RFI

RFI #: 66
Date: 2/22/2012
Job: EB-02 Keller Springs Lofts
Phone: 877-777-5115

Subject: Party Walls

**S2.36**

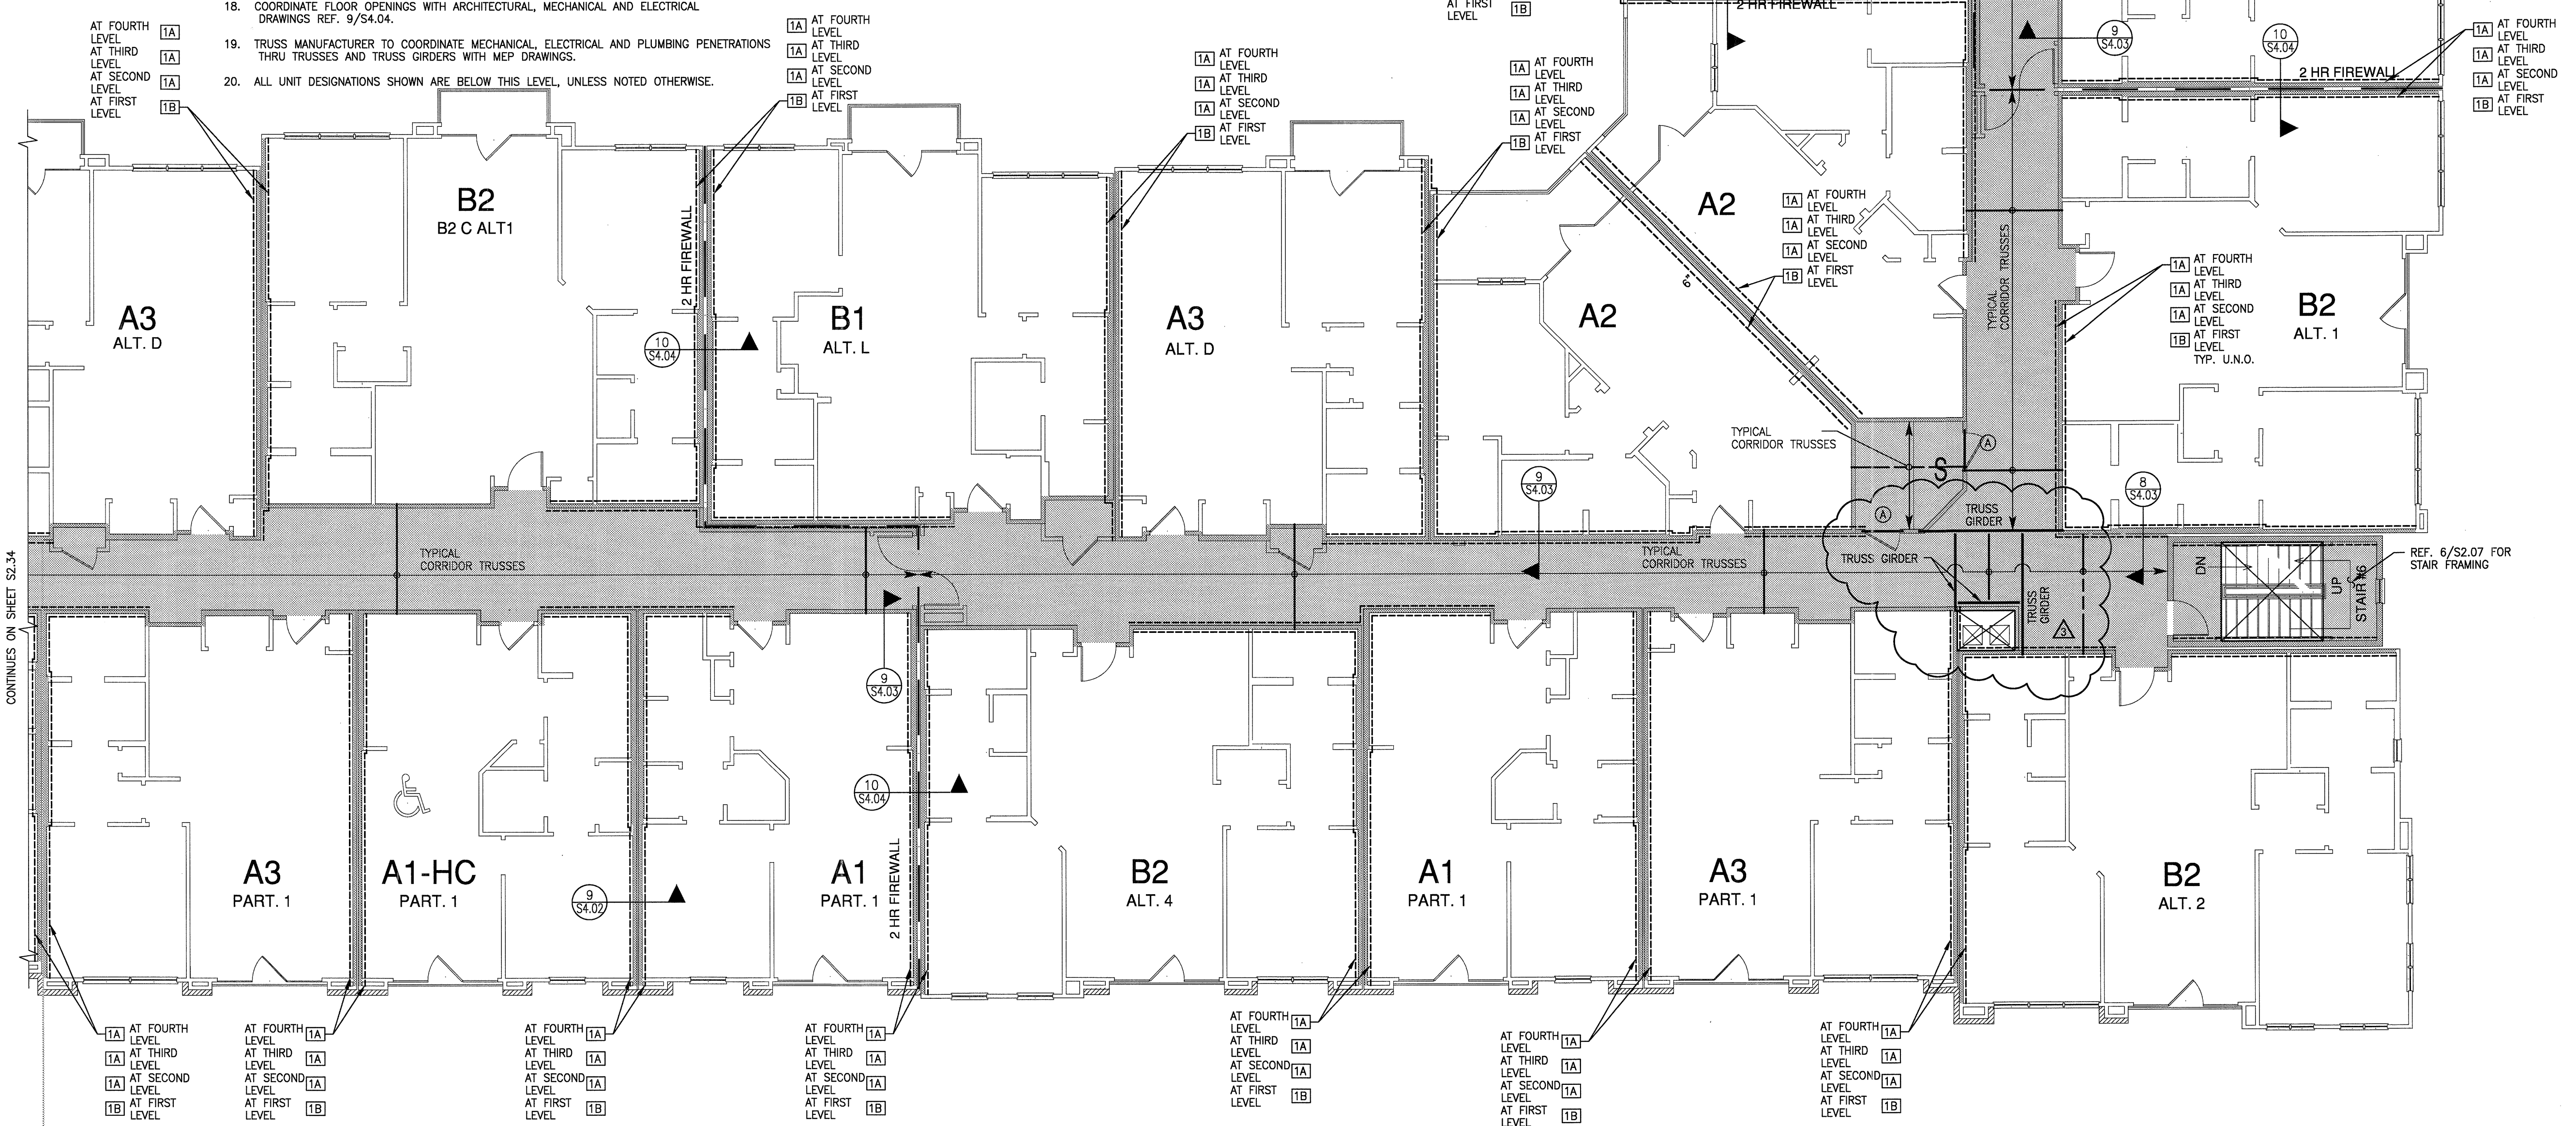
Details 1 & 2 on page 7.1 of the architectural drawings shows the wall make up to have 1 sheet of plywood in the middle of the double walls. The note tells us to refer to the structural drawings for the nailing pattern. Pages S2.31 through S2.36 gives us the shear wall designations. Our shear walls are types 1A & 1B. The shear wall schedule on page S1.03 tells us that the shear wall sheathing on types 1A & 1B is 1 layer of 5/8 gypsum wall board applied to 1 face of the wall. I cannot find where the shear wall schedule requires 15/32 plywood as a component of the double party walls. There are some details in the structural drawings on page S4.02 that show 15/32 sheathing but again it is not noted as a structural component. Please confirm that this was the correct understanding or not. (is OSB required as part of the double party wall make up?)

The 15/32" APA Rated Sheathing (noted in the Architectural drawings and in details 9, 10, and 11 on sheet S4.02 and details 5, 6, and 7 on sheet S5.01) is not part of the shear-wall assembly.

If the contractor provides adequate temporary bracing of the structure, the sheathing is not required structurally.
